# D&A Markakis Pty Ltd

**Re: Continued objection and unaddressed issues in relation to Application SSD 9194 at 13-23 Gibbons Street (SP 60485) proposing the construction of an 18 storey student accommodation development comprising of 419 rooms**

Figure 11: Afternoon Winter Sun View Diagrams showing impact of the amended proposal on St Lukes Church Building
(source AJ+C Architects)

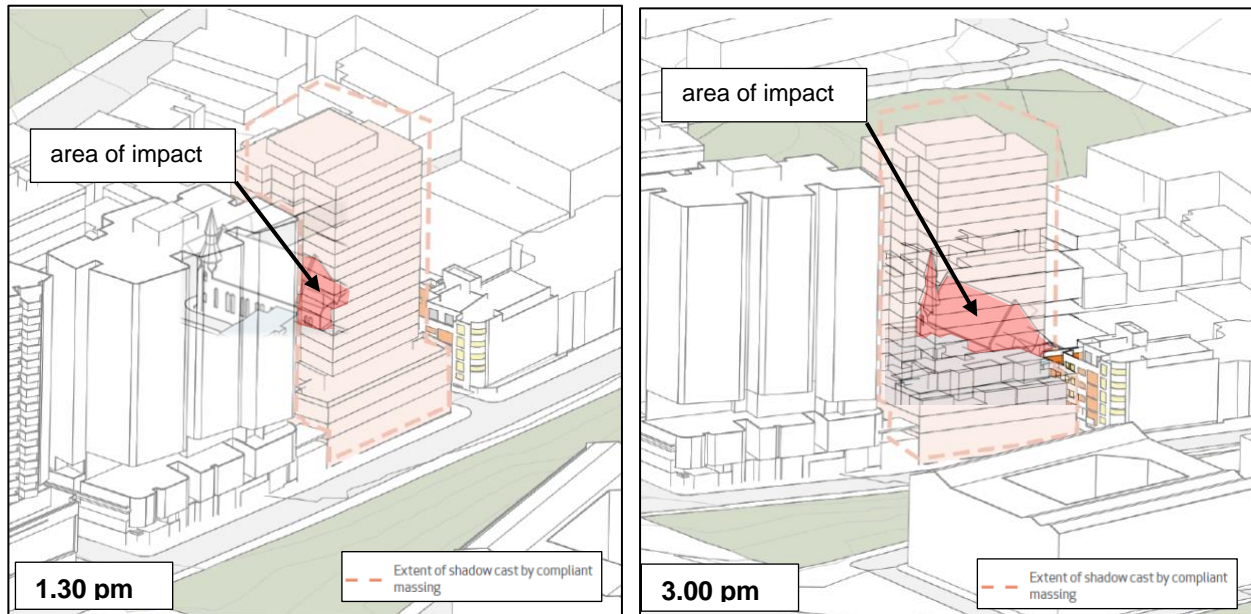
- In response to s 3.7.2 of the Applicant's 'Response to Submissions' Report, we submit that the impacts of the proposed development on St Luke's Church cannot be mitigated by considering the potential overshadowing of alternative 'compliant' developments (as whilst they may be by definition compliant, they are still not necessarily approved, well planned, well considered or result in a good planning outcome – this is why developments go through an approval process). Furthermore, 'future' adjoining buildings are speculative, not approved and cannot be relied upon in overshadowing analysis in reaching a fair and reasonable planning outcome. The fact is that the current development proposal is proposing immense and detrimental overshadowing to St Luke's Church which remains unchanged in its revisions and which undermines the visual impact, solar access to and heritage status of the property. We would also note that the church building, although no longer functioning as a church, from its low intensity current use as a kitchen supply store is even more inclusive and open to the community through set trading hours open for all to enter and appreciate the heritage architecture and features. Resultantly, the existing solar access is vital to be retained and preserved for the former church building, its occupants and for the reasonable enjoyment of the locality and community.

**Figure 19: Typical tower floorplan showing encroachments into 3 storey height control area**  
(Base Image source: AJ+C Architects)

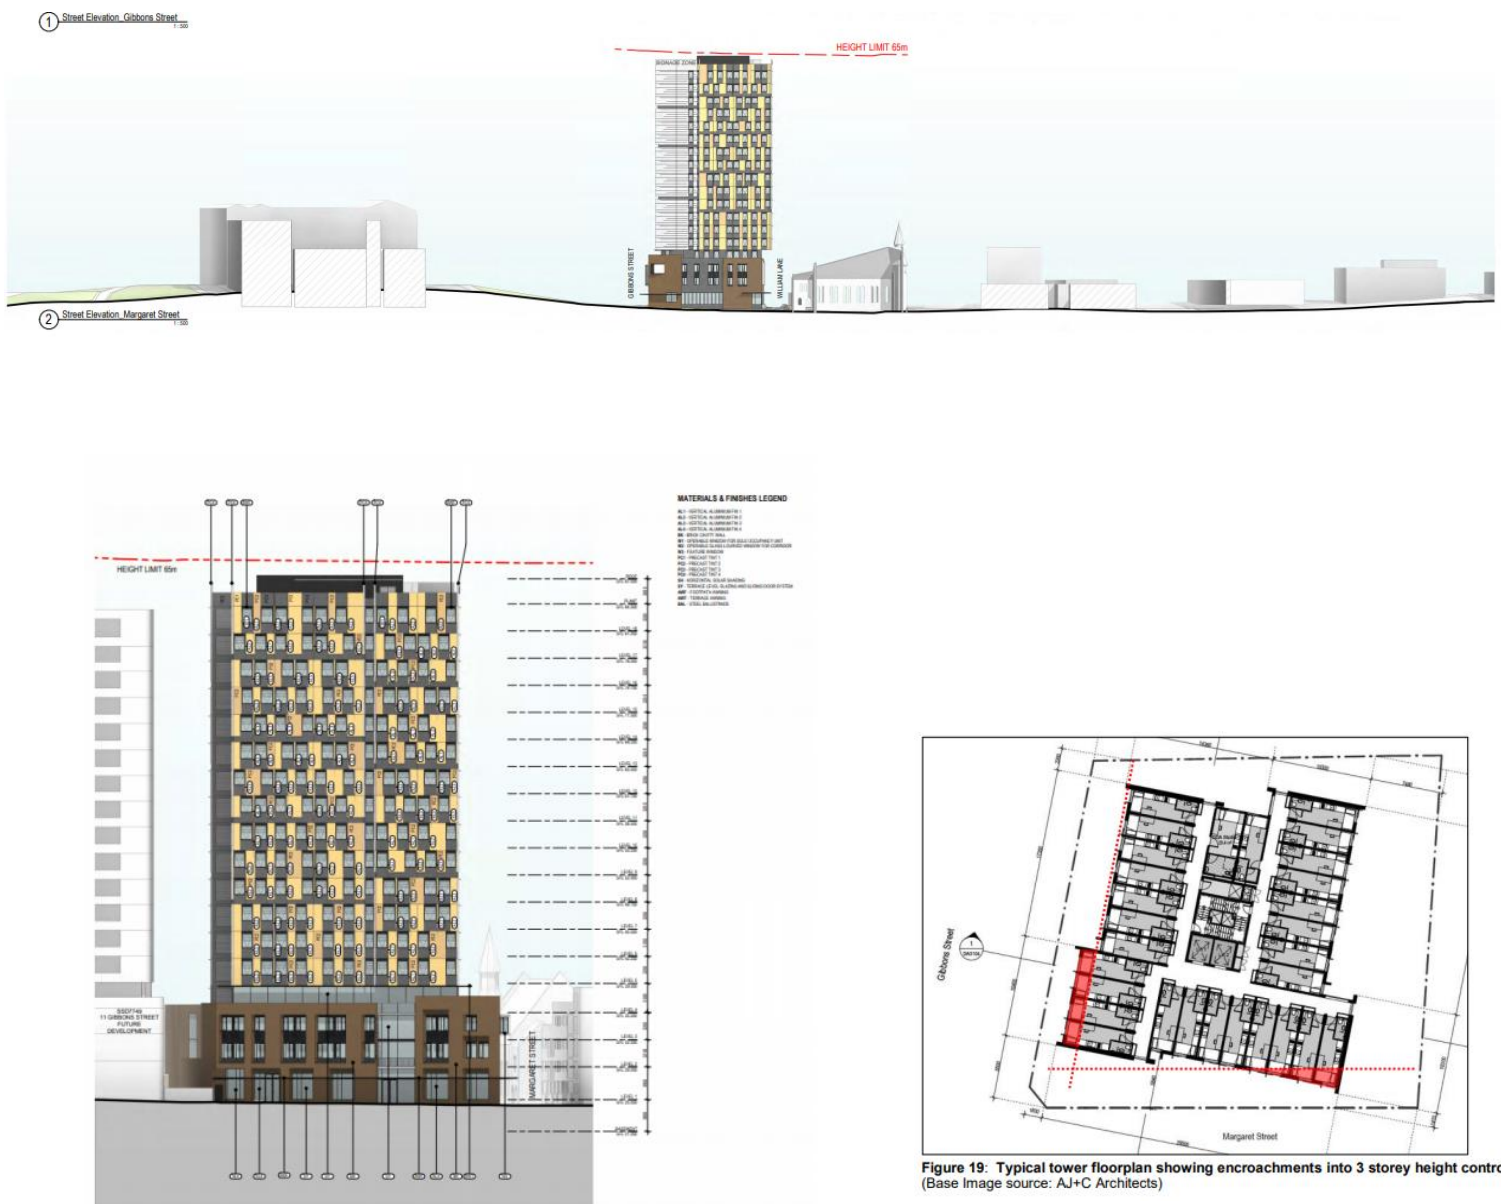
- In response to s 3.11 of the Applicant's 'Response to Submissions' Report, we query if the proposed development still encroaches into the 3 storey height control area (if the applicant could please clarify this to the Department and to those who have made public/organisation submissions concerned about setbacks, bulk and scale). From reviewing the placement and size of the floor plates for the proposed building and the revised setbacks, the building is clearly of unreasonably enormous bulk and scale to the detriment of the surrounding properties, specifically in relation to its close proximity to the buildings along the Southern side of Margaret Street, and is especially detrimental to the visual prominence required and impact on the heritage significance of the church building for its occupants and the community. The above extract reflects a proposed development that is clearly too large with its massing imposing on St Luke's Church and the properties along the Southern side of Margaret St. We also note that in the Applicant's 'Response to Submissions' Report, Figure 21 is clearly a closer photograph of the existing building at 13-23 Gibbons St Redfern than of the rendered photograph of the proposed development in Figure 22 and therefore the comparison between Figure 21 and Figure 22 is not a fair and reasonable comparison of the overall visual impact and reasonable reflection of the proposed development's impact. Figure 22 also crops the top of the proposed development which negates the visual impact from its increased height. In consideration of all of the above, we arduously advocate that the proposed development should be considerably
